Reference: JH / 12690 – 09.08.2021

LLFA Objection – Condition 2

Reference: RE: 6/2021/0505/COND – H R Owen. Mosquito Way, Hatfield, AL10 9WN

Drawing Title
DRAINAGE CONSTRUCTION DETAILS

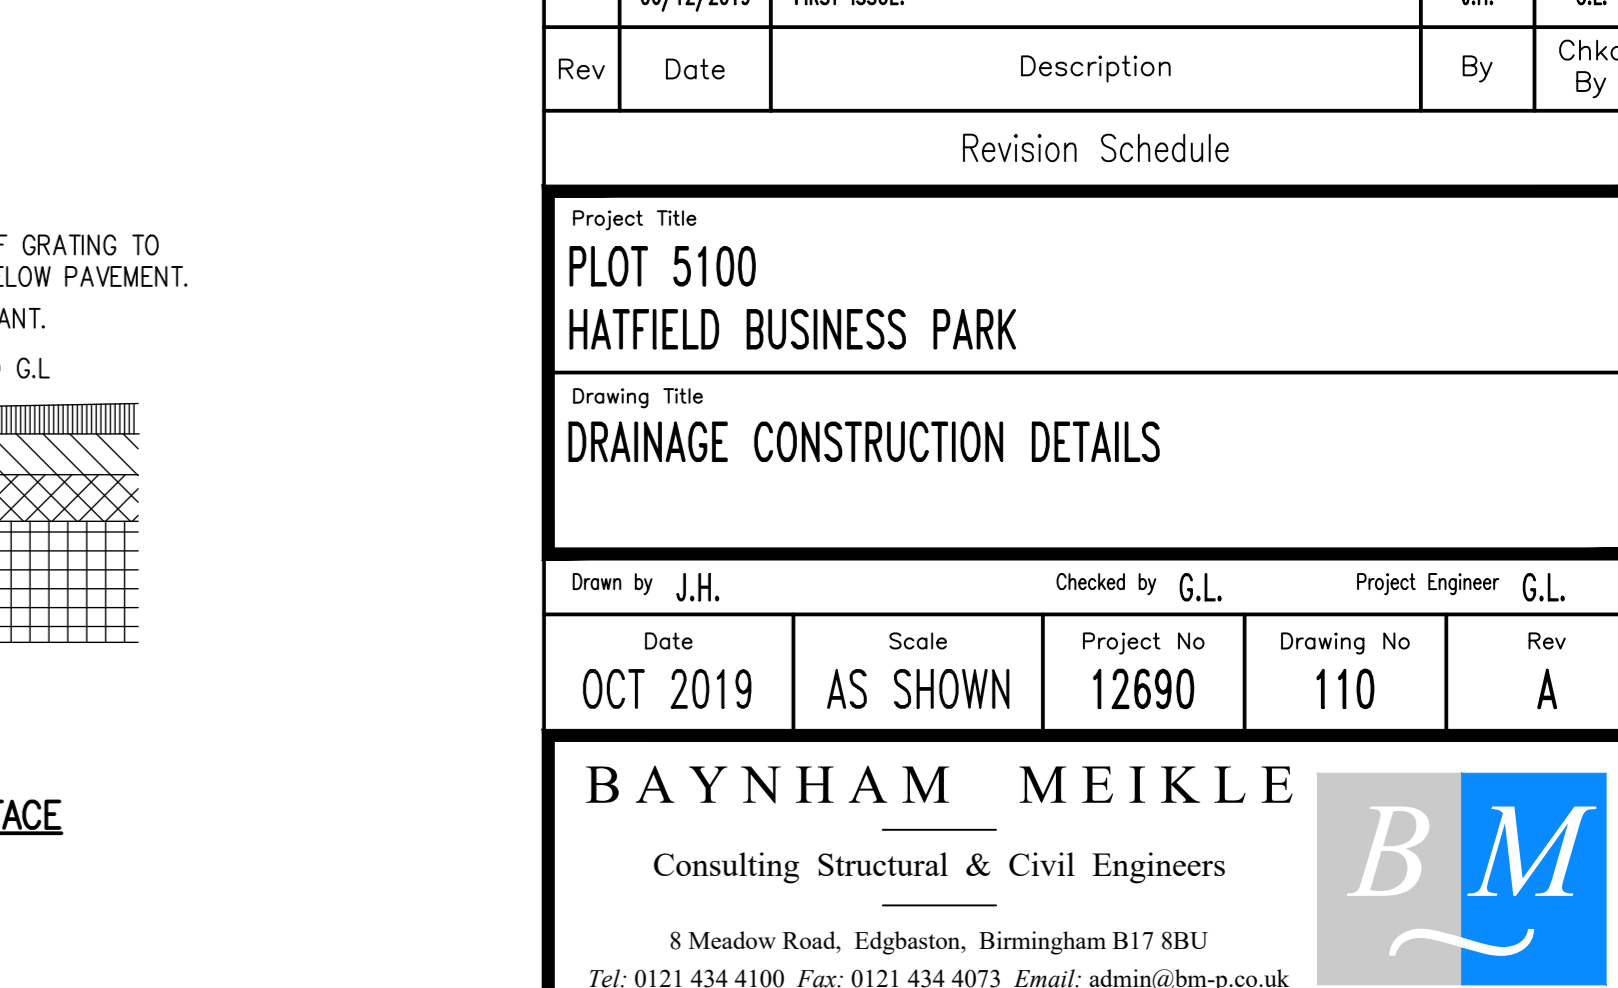
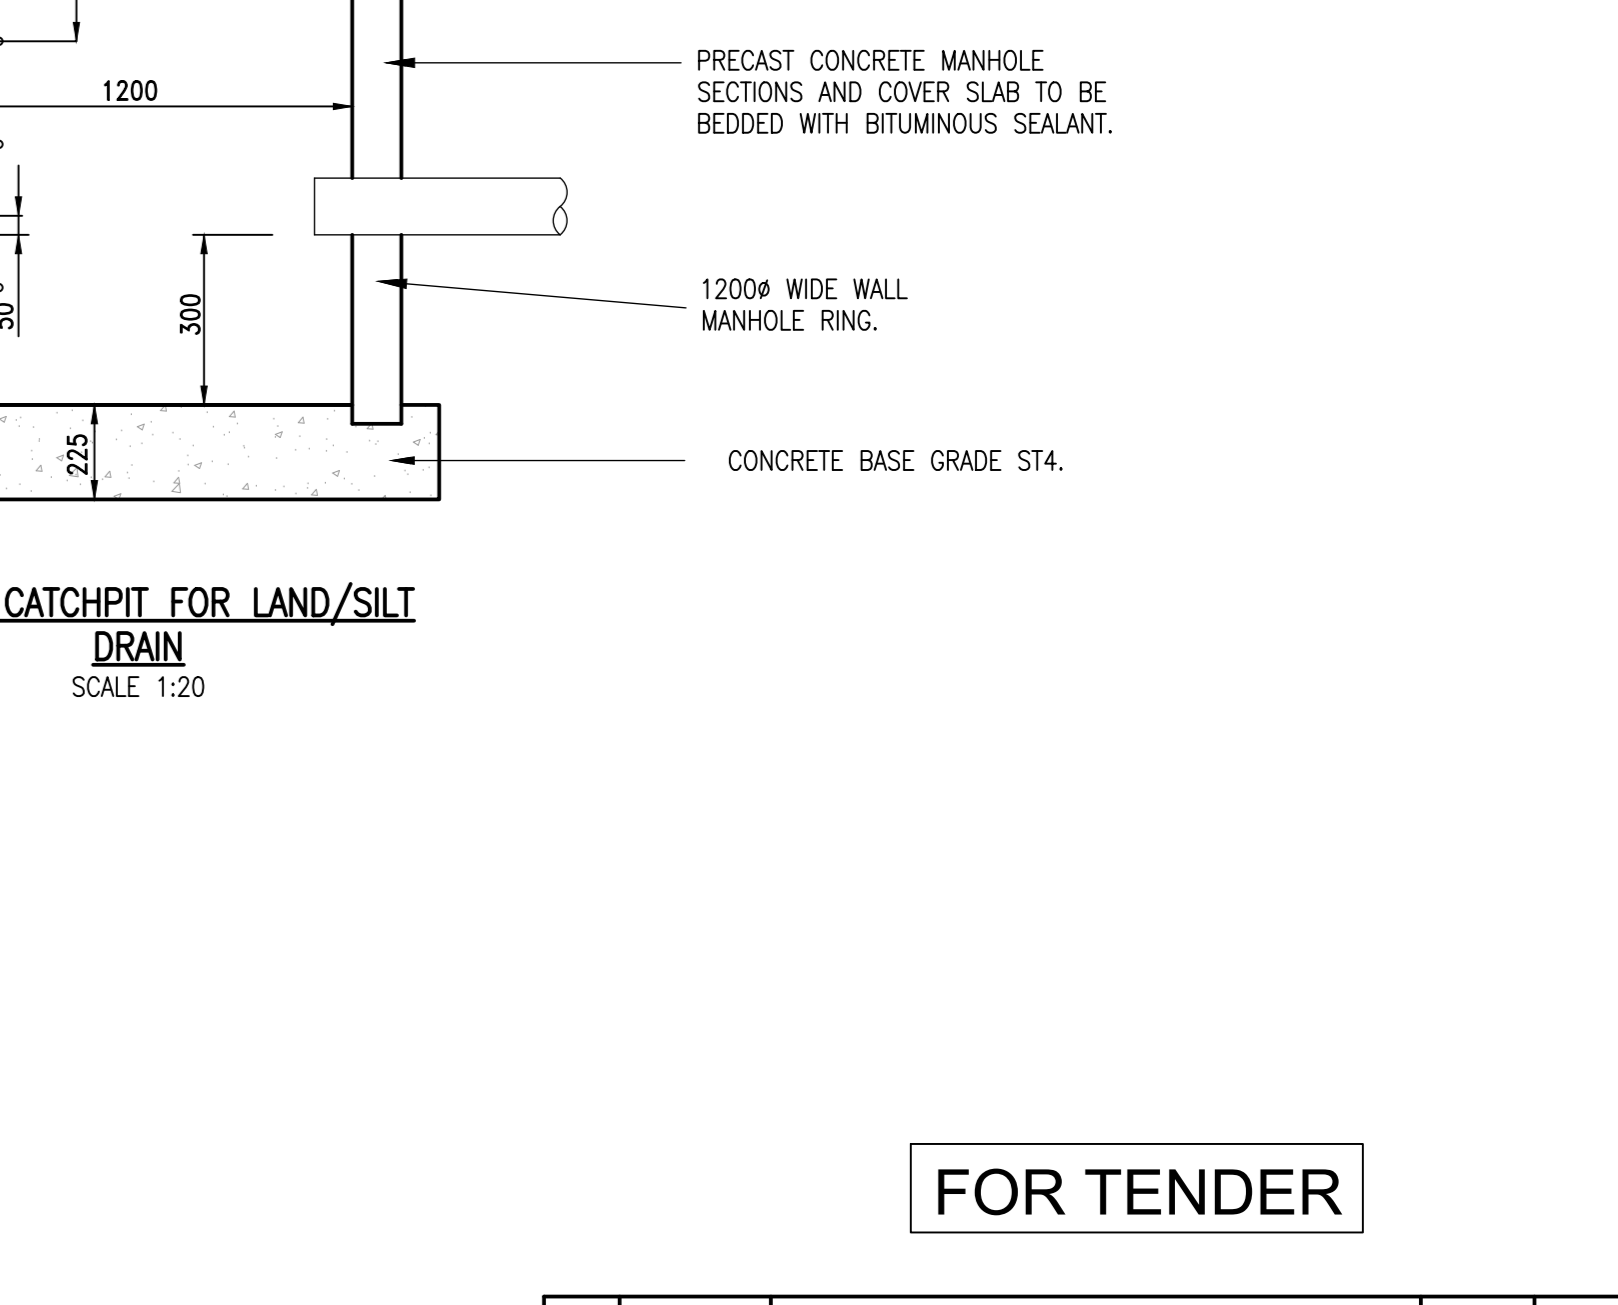
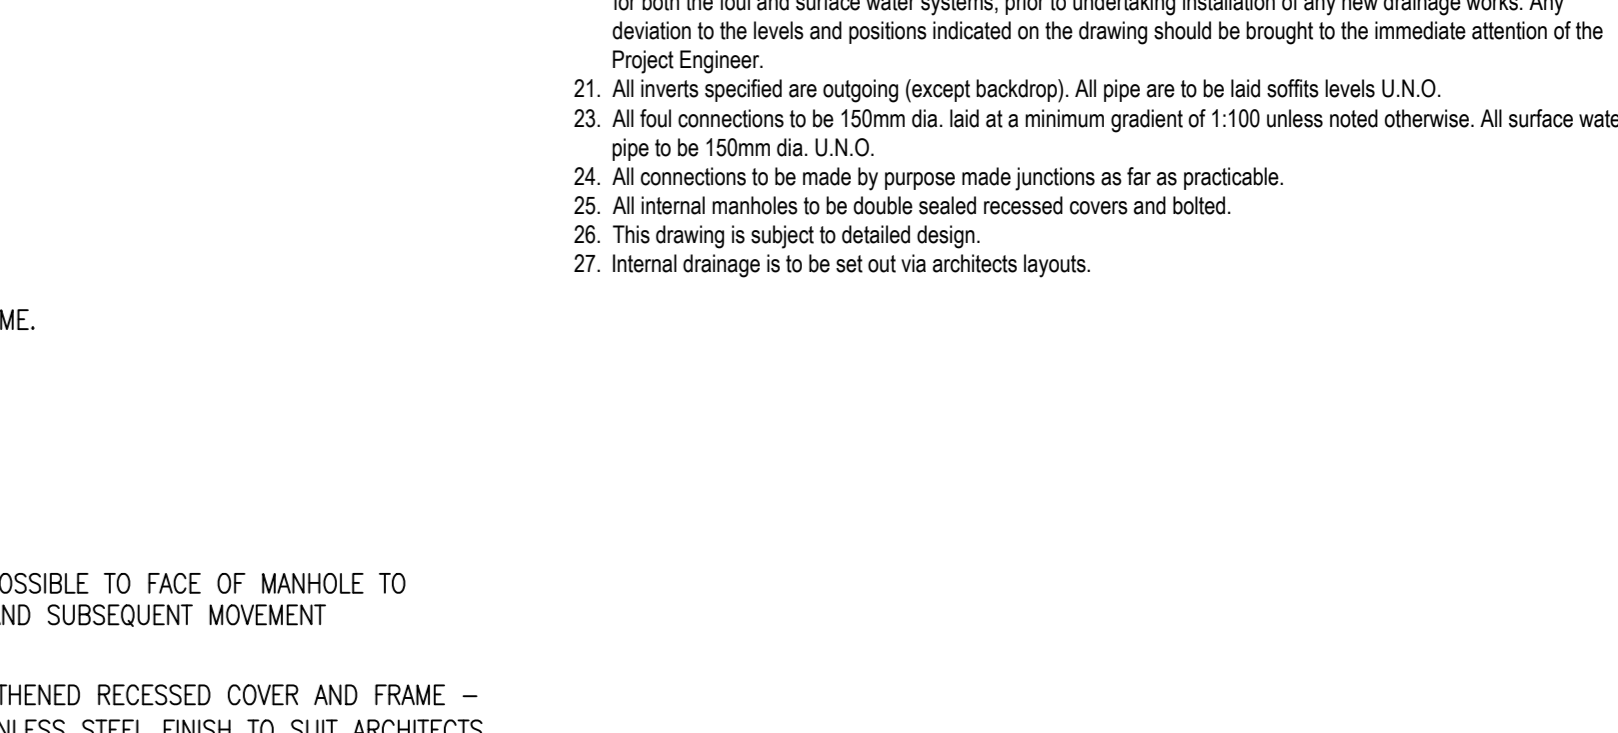
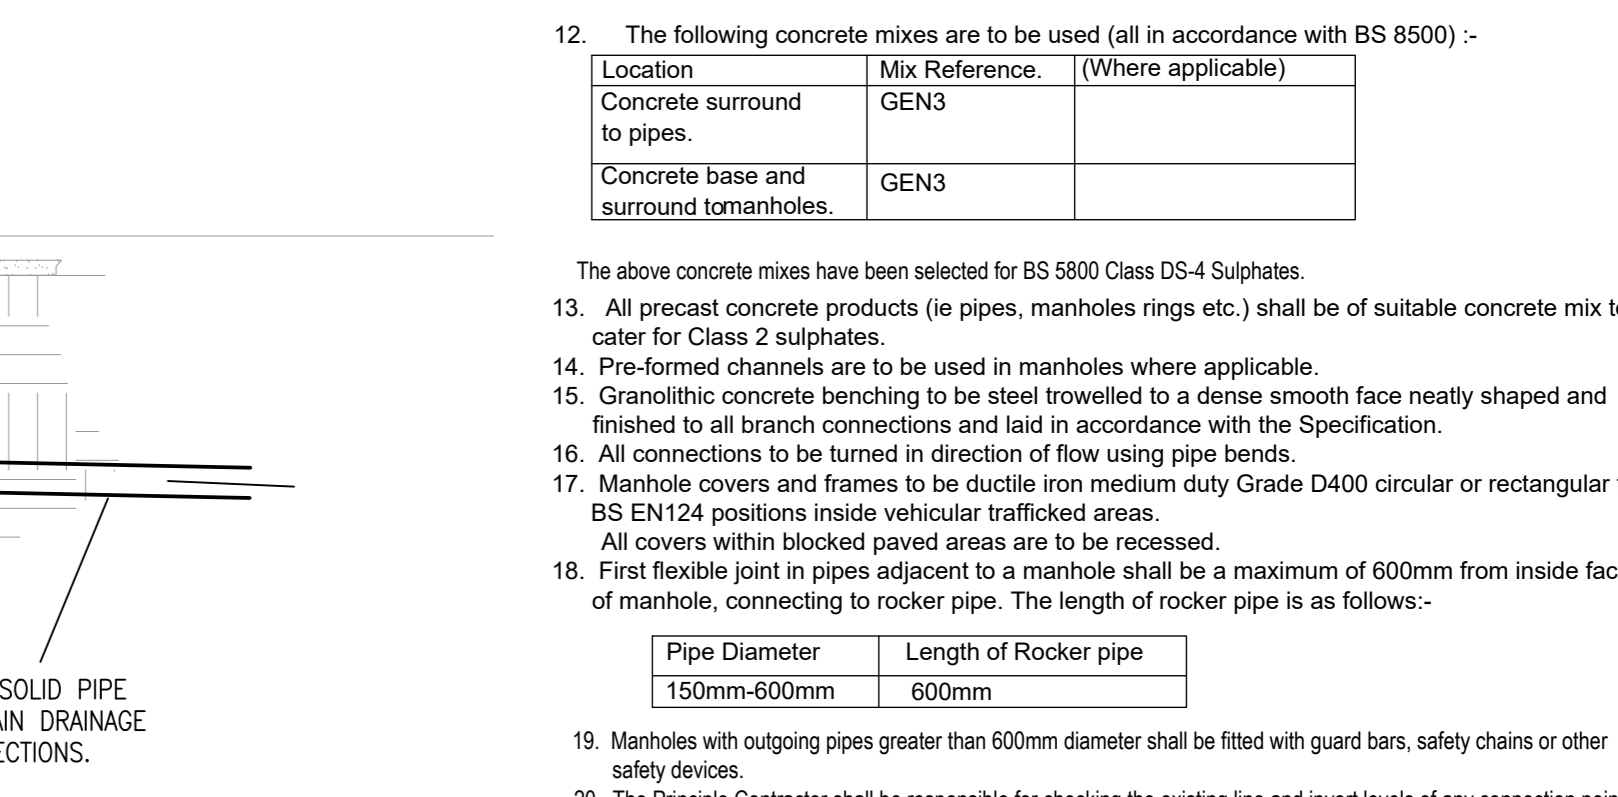
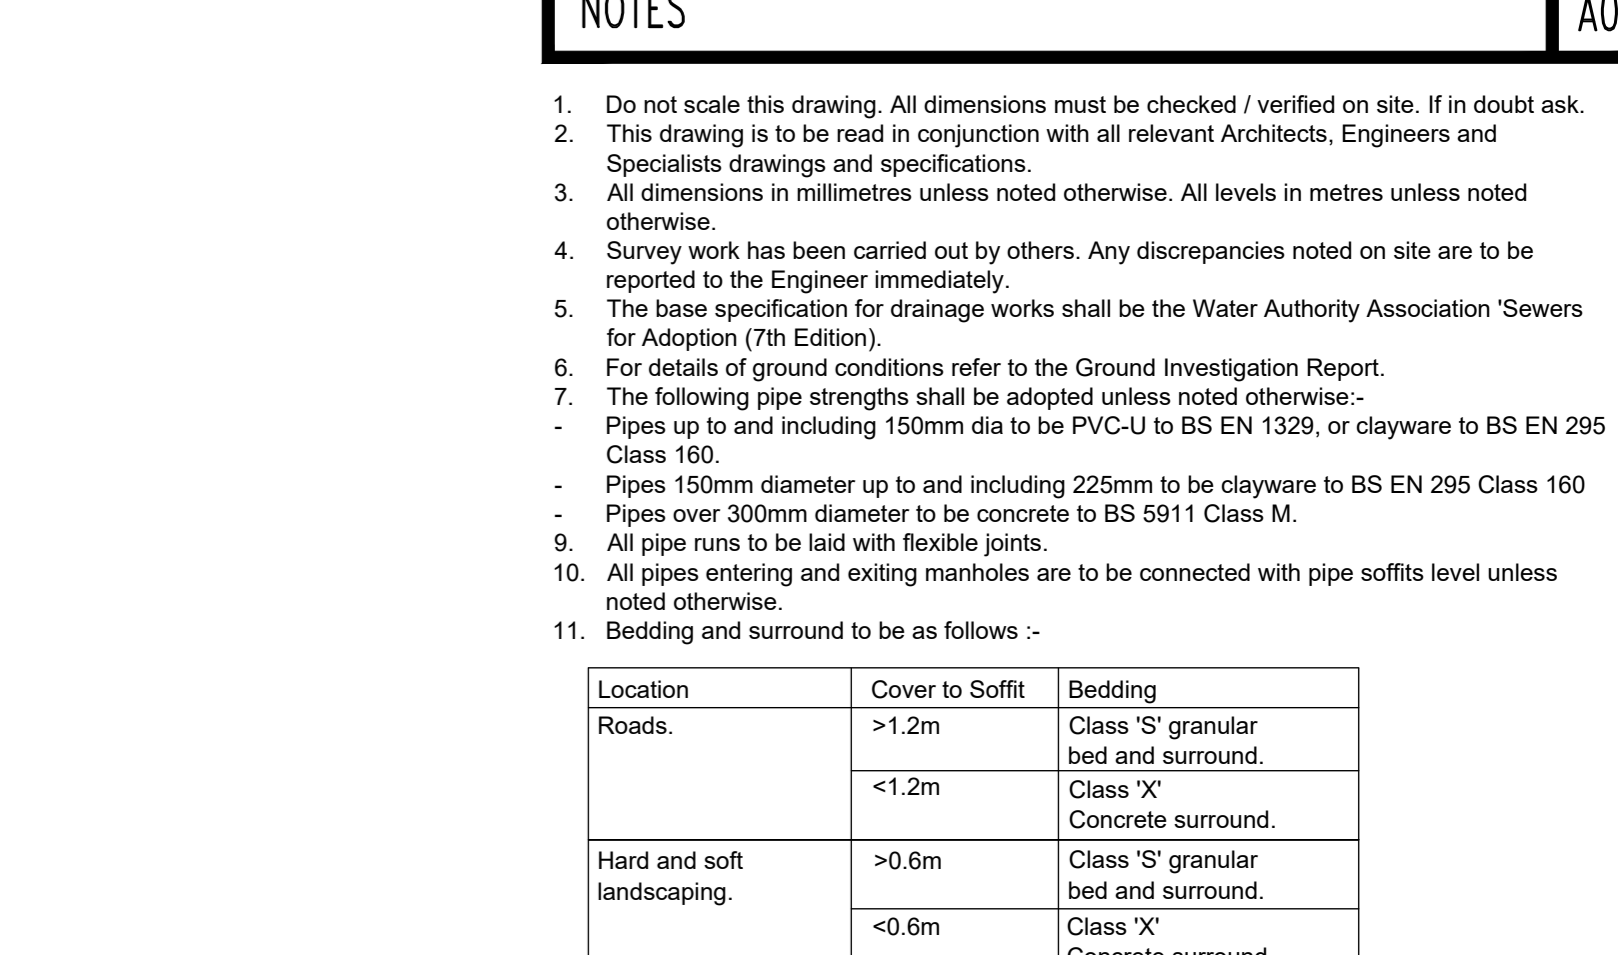
We are pleased with the proposed use of permeable paving for the roads and proximal to the parking spaces. However, we would still be concerned with the road gullies at the access road draining directly into the surface water network and subsequently discharge with no SuDS management and treatment. Treatment should be provided through the use of above-ground SuDS such as permeable paving or filter drains etc. Gully outlets have been amended to discharge into the permeable paving rather than SMH23. This will offer treatment to the 250m² drained by the gullies prior to entering the storm network.

We would like to remind that no surface water drainage should be provided beneath a building. The applicant had clarified this and states that the storm run between SMH15 and SMH17 is not under a building, however the Landscape General Arrangement Plan indicates a form of structure/building here. Please could this be clarified. The drainage run between SMH15 and SMH17 is not beneath the building. The extent of building is shown in a pink hatch within the below screenshot.

In addition, in the north western part of the site we have noticed that rainwater pipes are proposed to discharge at flood level. We would like to advise that appropriate connections into the wider network should be provided. No discharge to impermeable surface will be allowed. This is an old reference and is not shown on the latest drainage plan. No roof water is discharging to floor level. Screen shot shown below.

The applicant refers to the latest drainage plan which may resolve the above query, as well as our previous questions regarding SMH26. However, this latest drainage plan does not appear available on the planning portal. Latest plan is to be uploaded onto the planning portal.

We would like to remind that all updates should be appropriately indicated in the drainage modelling and on the drainage layout. Half drain down times have not been submitted in support of the strategy in the latest calculations. Please note they should not exceed 24 hours. Worst case half drain times are shown within the calculations, the below screen shot highlights an example of this. 1 year shown on page 11, 30 year shown on page 14 and 100 year + CC% shown on page 17.
